# CITY OF ALBUQUERQUE

January 31, 2019

RE: **1<sup>st</sup> Nations Community Healthsource**  
**5608 Zuni SE**  
**Revised Grading and Drainage Plan**  
**Engineers Stamp Date: 1/15/19**  
**Drainage File: L18D047**

C-101

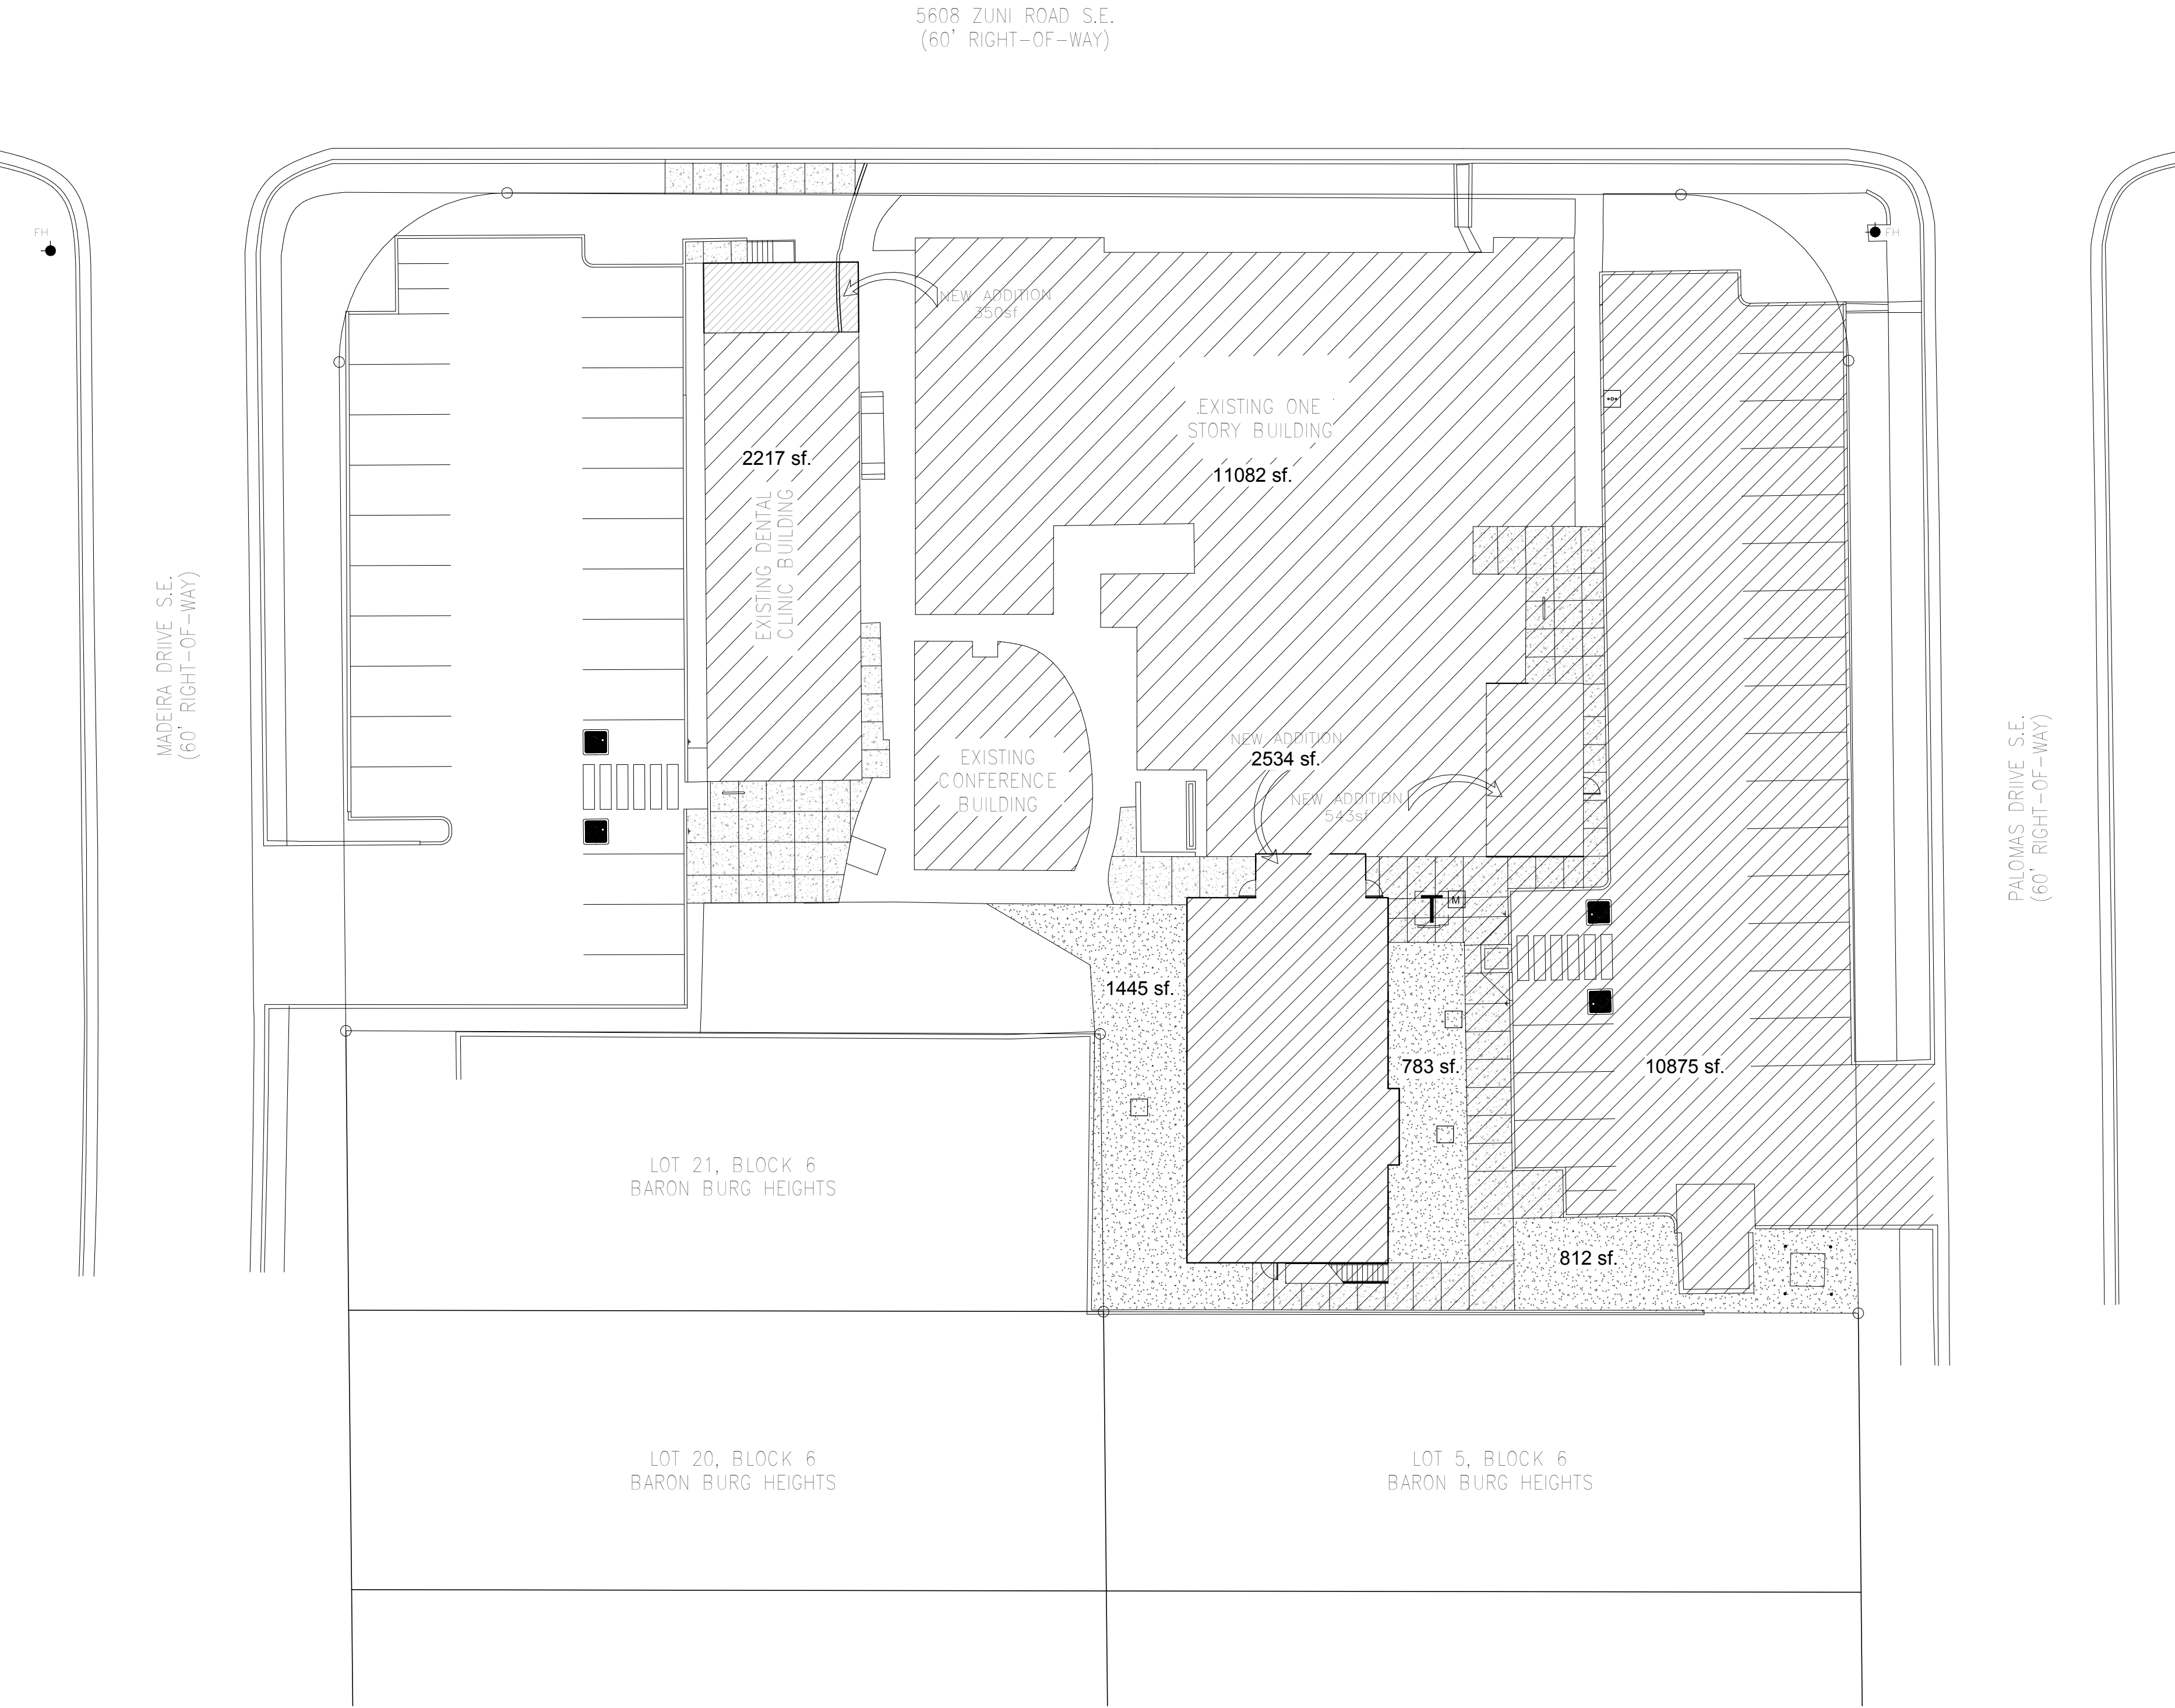
1. A digital (.pdf) submittal, emailed to [PLNDRS@cabq.gov](mailto:PLNDRS@cabq.gov) is required.
2. Because this is a resubmittal of a previously approved plan, the entire plan needs to be included; the grading and drainage plan for the east side of the site needs to be restamped and included. If any changes were made to the plan on the east side, these should be included.

3. The plan needs to clearly state: that the applicant could provide on-site management of the storm water quality volume (SWQV), that the applicant does not wish to provide on-site management, and is requesting to pay a fee-in-lieu of onsite management instead. This site could easily provide onsite retention by relocating utilities to accommodate a pond, by locating the pond under the parking lot (underground storage) or grading the parking lot to drain to another location where utility conflicts do not exist.

6. Include project benchmark and datum.

C-100A

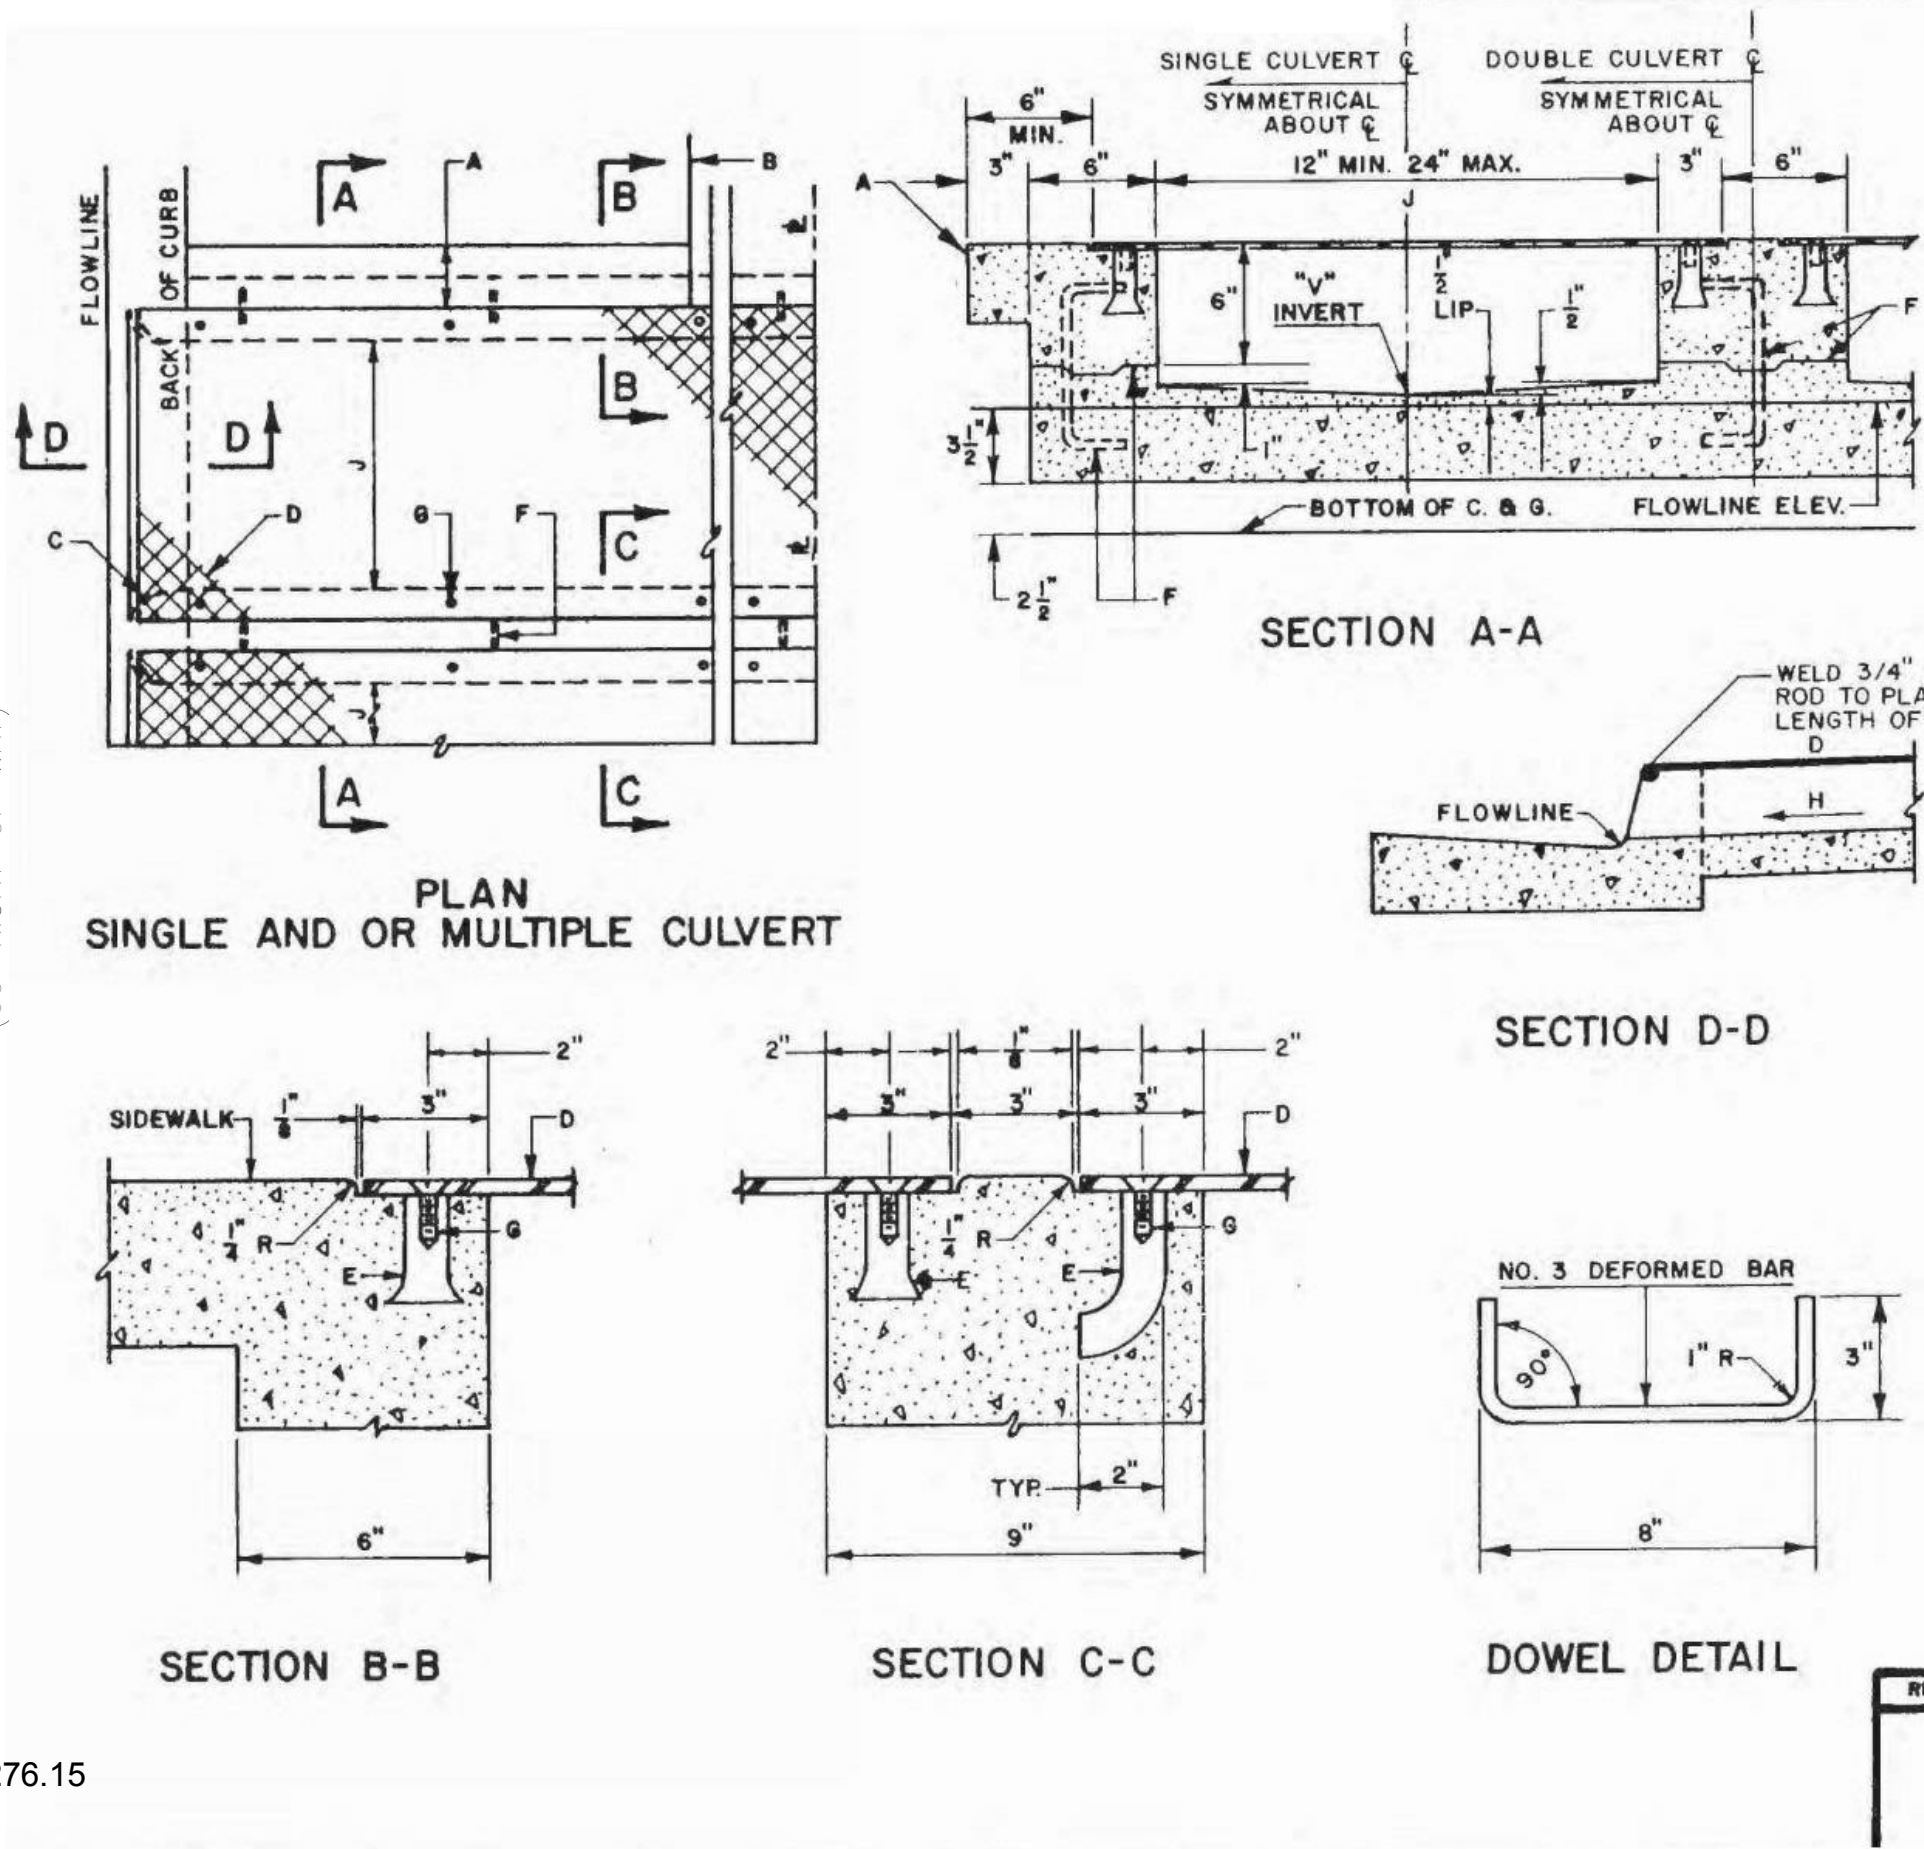
5. An SO-19 Permit will be required; please include the [standard SO-19](#) notes on the grading plan. In Keyed Note 1, an excavation/barricading permit is also needed.
